## DEVELOPMENT FACILITATION TEAM

### Planning - Case Comments

**Project Number:** PR-2022-007999

**Project Name:** 1700 Unser Blvd. NW

ZONING SETBACKS (NR-LM)
 Front: 5 ft
 Side/Rear: 0 ft

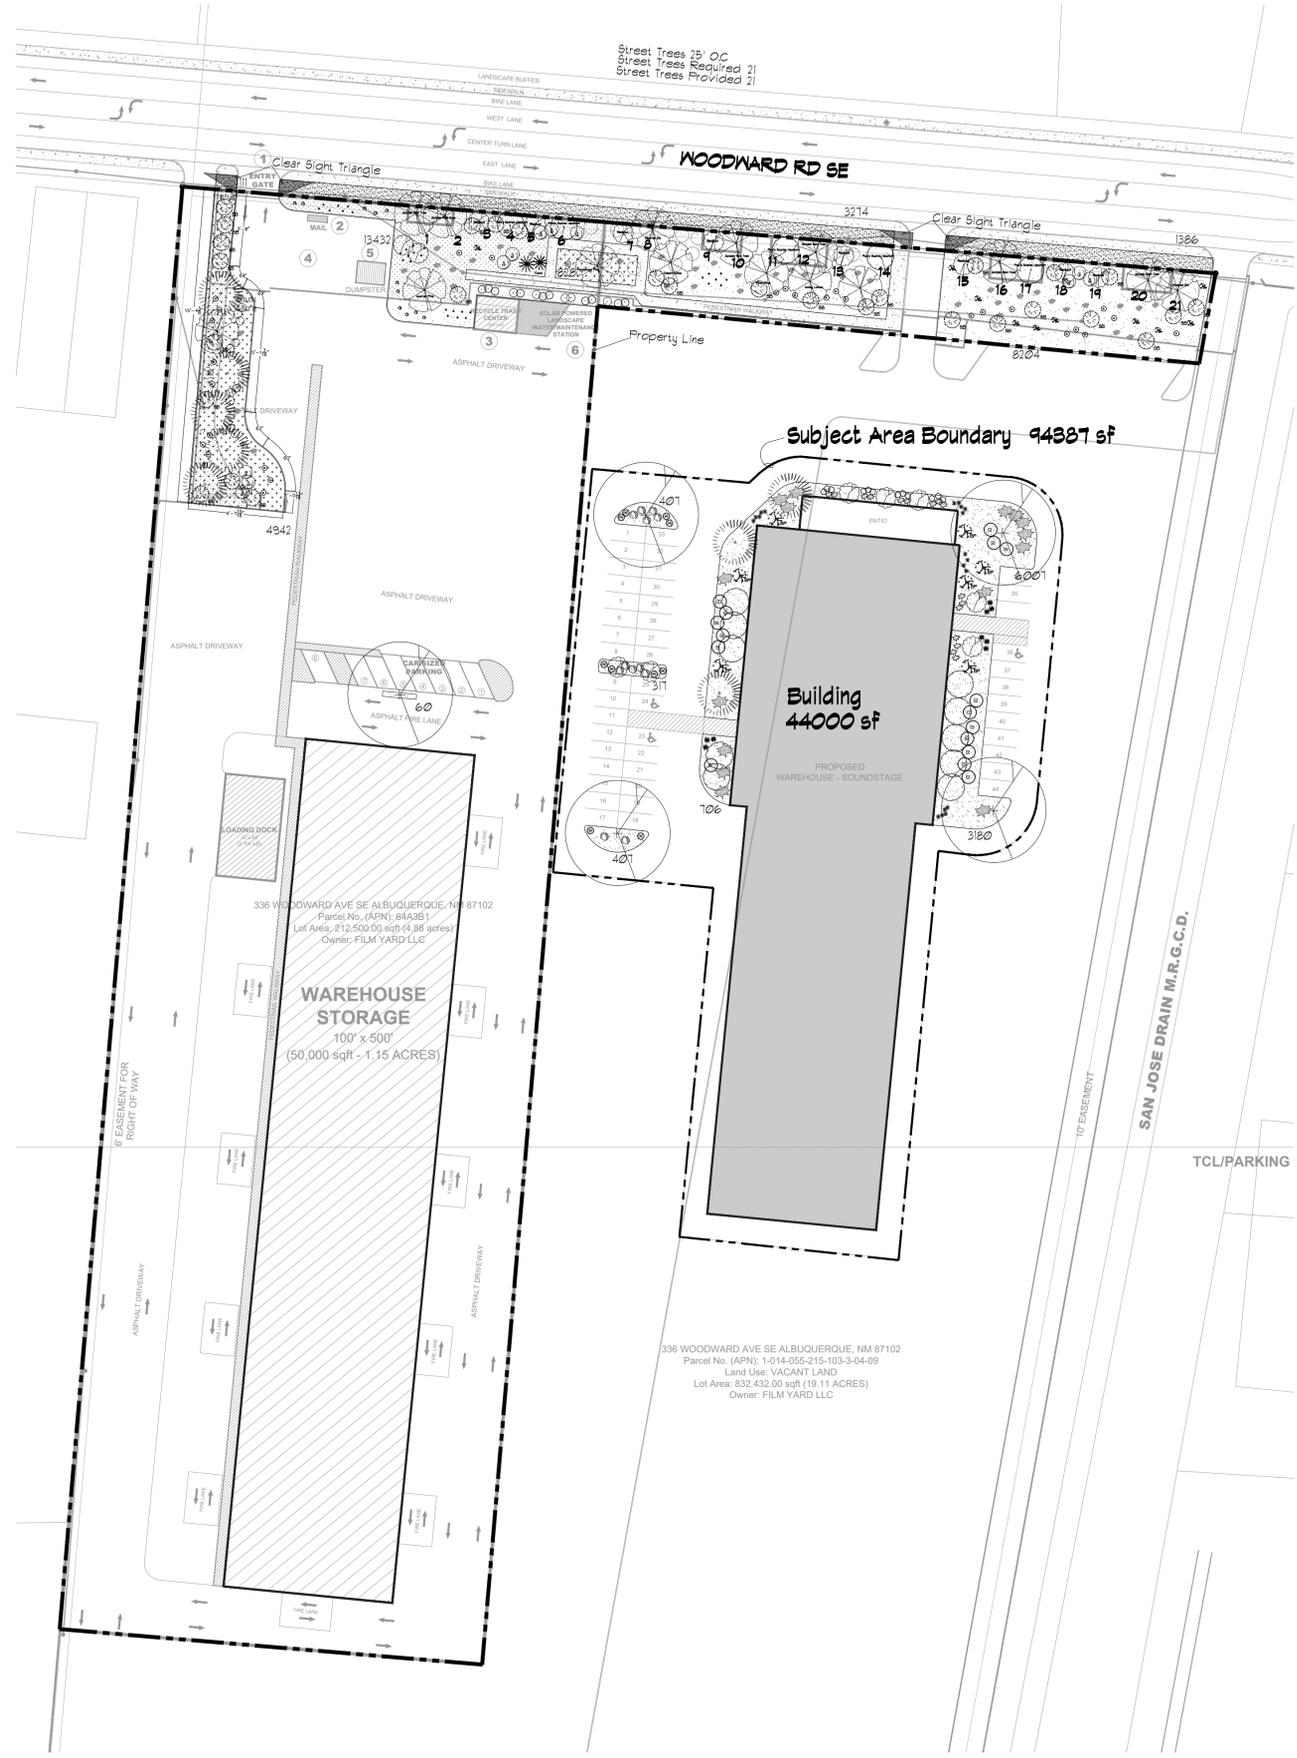
- a. Update all sheets (site plan, landscaping, grading & drainage, TCL and utility) to accurately reflect form of developed phases on site, including both structures, new landscaping areas, new parking areas and outdoor storage areas.

- b. All existing and planned outdoor storage areas shall be listed on the Site Plan.
  1. Any fences and screening of these outdoor storage areas should be included on site plan and detail sheet.

- c. All existing outdoor storage areas on lots 64A4 and 224 shall be called out on Site Plan.

- d. Outdoor Vehicle Storage shall be added to the list of allowable uses on the site plan.
  1. All existing outdoor vehicle storage areas shall be called out on the site plan, including those stored on the site for loading/unloading and film production purposes.

- e. Parking calculations shall be updated to show total parking spaces required and provided on subject area.
  1. Update bicycle parking calculations to reflect how many bike spaces per bike rack are provided and the total amount of individual bicycle spaces on the subject area.

1. Update Site Plan Note #5 to accurately reflect signs on entire site.
2. Provide sign details on detail sheet (see Condition of Approval #4).
3. Update site plan to indicate all sign locations on the site.

1. All walls and fences (internal and around perimeter) shall be shown on the site plan.
2. All walls and fence detail shall be shown on detail sheet for each that provide height, type/material and any screening materials (e.g. Fabric, slats).

**Updated site plan sheets showing existing and proposed structures, new landscaped areas, as well as parking and storage areas, have been provided by the applicant.**

**The applicant has provided an updated Site Plan that shows the location of existing and planned outdoor storage areas, including any fences, walls and screening materials surrounding outdoor storage areas on the site plan and detail sheet.**

**The applicant has provided an updated Site Plan that shows the land use of lots 64A4 and 224.**

**The applicant has provided an updated Site Plan that includes Outdoor Vehicle Storage as a land use and has showed that Outdoor Vehicle Storage will be limited to the southern portion of the subject site.**

**The applicant has provided an updated Site Plan that accurately reflects the required and provided parking calculations, including bicycle parking calculations and location on site.**

**The applicant has provided an updated Site Plan that accurately reflects the location and number of signs on the site, including sign detail on the detail sheet.**

**The applicant has provided an updated Site Plan that accurately reflects the location of all walls and fences on the site, including the specifications of all walls and fences on the detail sheet.**

Landscape Plan

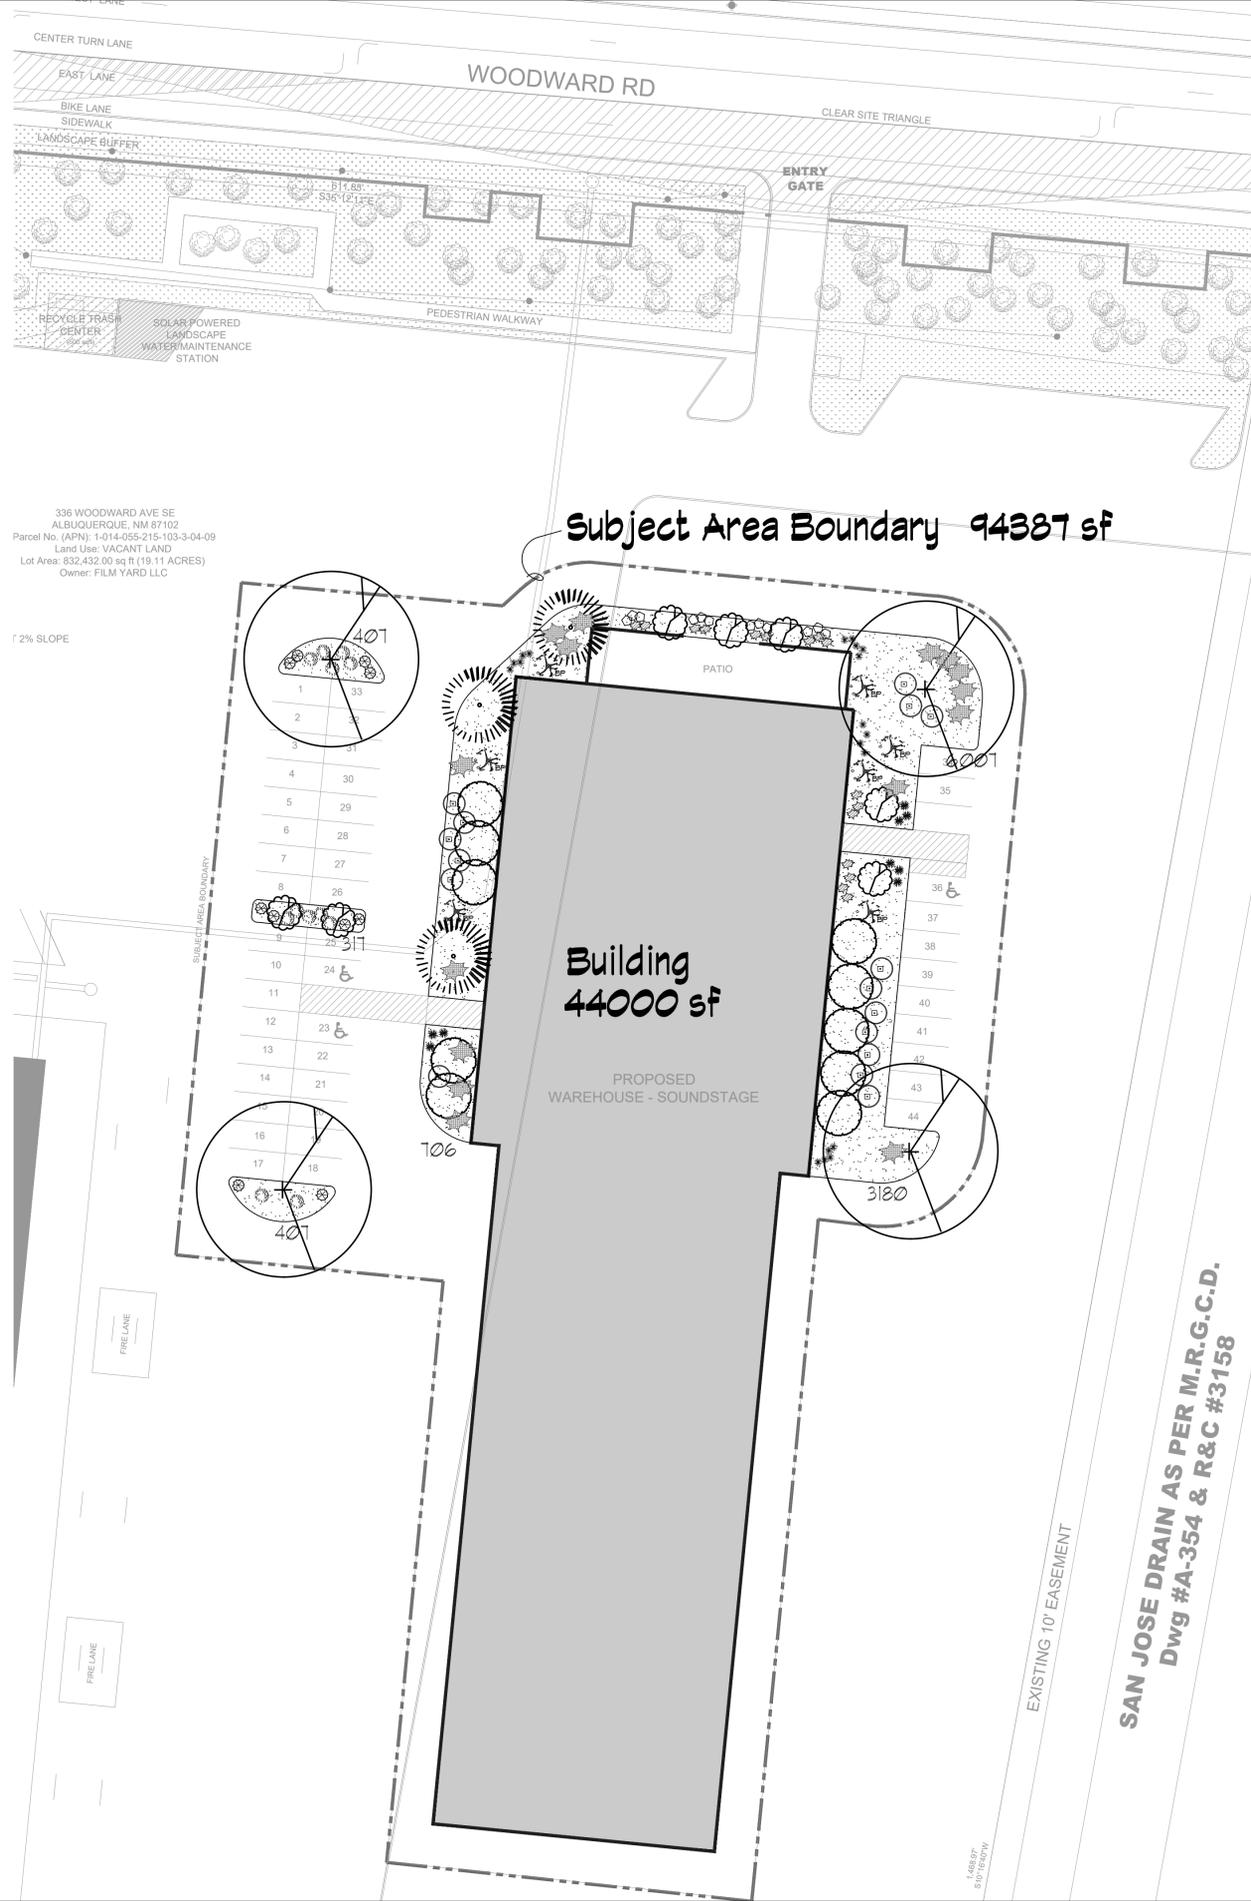
6. Landscaping Plan: Provide an additional, new overall Landscape Plan sheet (of both Phase 1 and 2) that shows the landscaping, calculations and landscape legend for the subject area.

**The applicant has provided updated Landscaping Plan/Sheets that accurately show the total landscaping calculations, landscaping provided, trees, shrubs for the subject area of Phases 1 and 2. The applicant has updated the landscape legend and re-titled sheets for consistency and clarity.**

Mitchell Associates, Inc
Landscape Architect
DANNY D. MITCHELL
239
REGISTERED LANDSCAPE ARCHITECT
Dec. 4, 2025
Copyright 2025, Mitchell Associates Inc.
PROJECT NO: 2024-055
DRAWING NO: **LS-101**

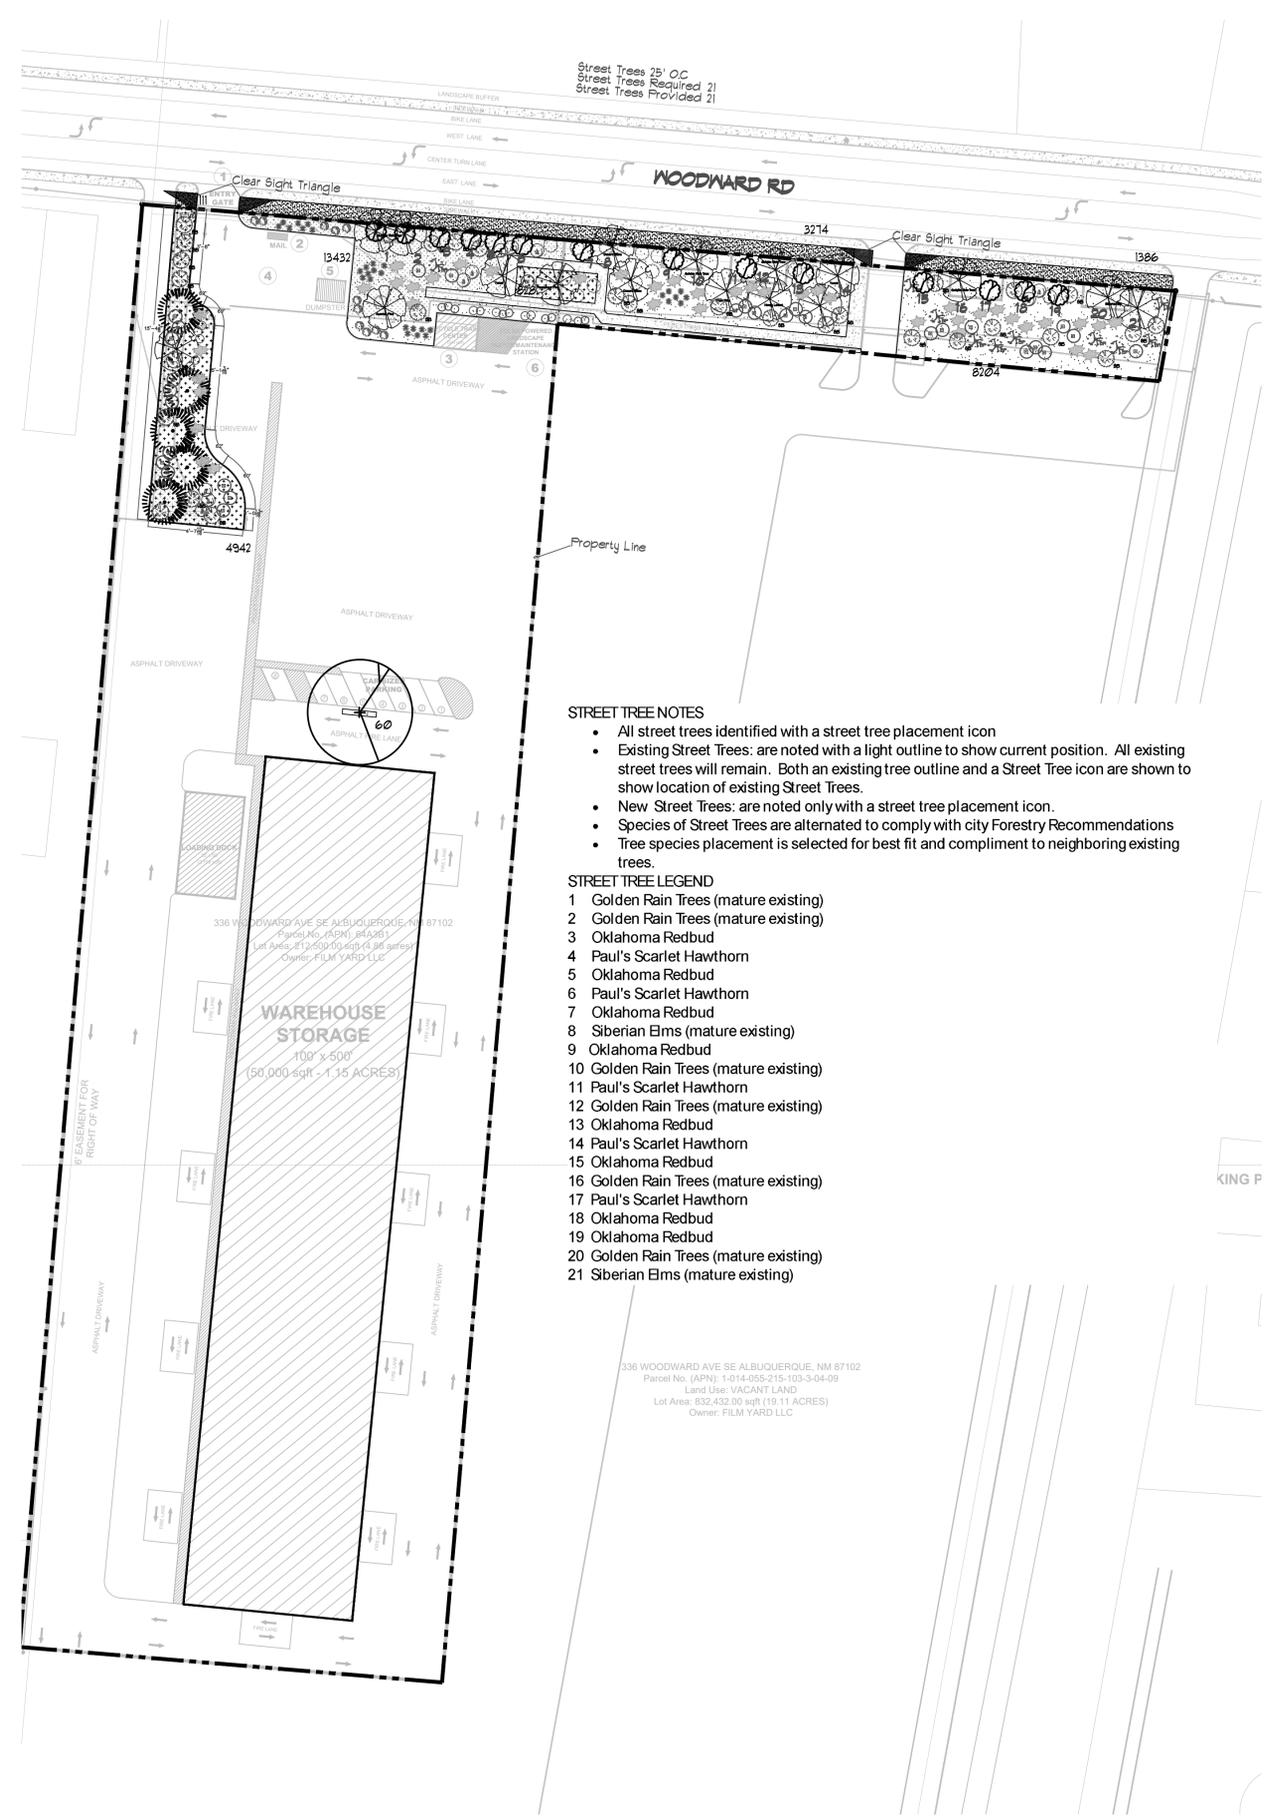
1. Landscaping sheet LS-101 shall remain the landscaping sheet for the current subject area of this request.
- Update Total Tree and Total Shrub calculations to accurately reflect total amount of trees and shrubs that are on this sheet.
2. Re-name previous Landscaping sheet LS-101, which showed landscaping detail for lot 64A3B1 (PR-2022-007999/SI-2023-01621), to sheet LS-201.

PARKING LAYOUT
Not to Scale

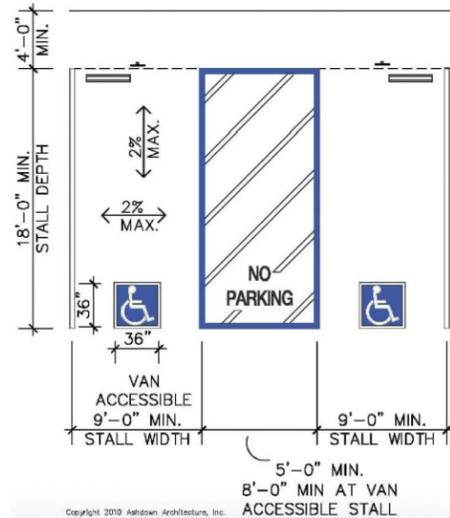
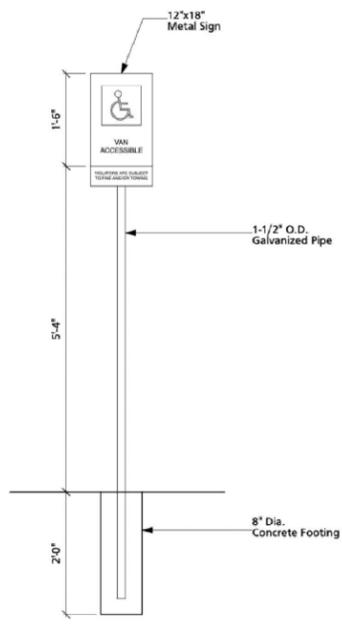
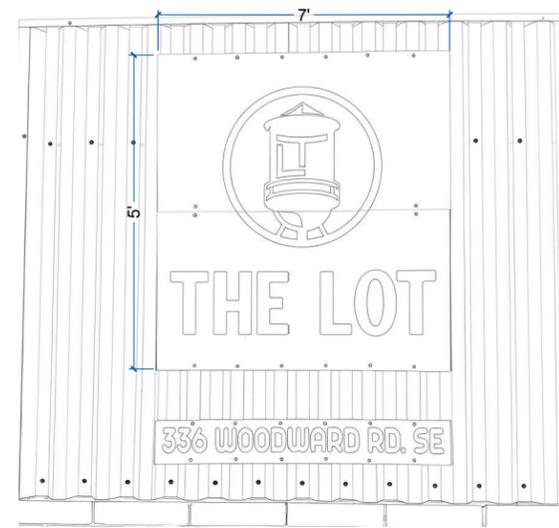
7. Provide separate Detail Sheet for parking related barriers and signage, walls and fences, and wall signs.

**The applicant has provided a Detail Sheet that provides specifications for walls, fences, signs and parking related fixtures.**
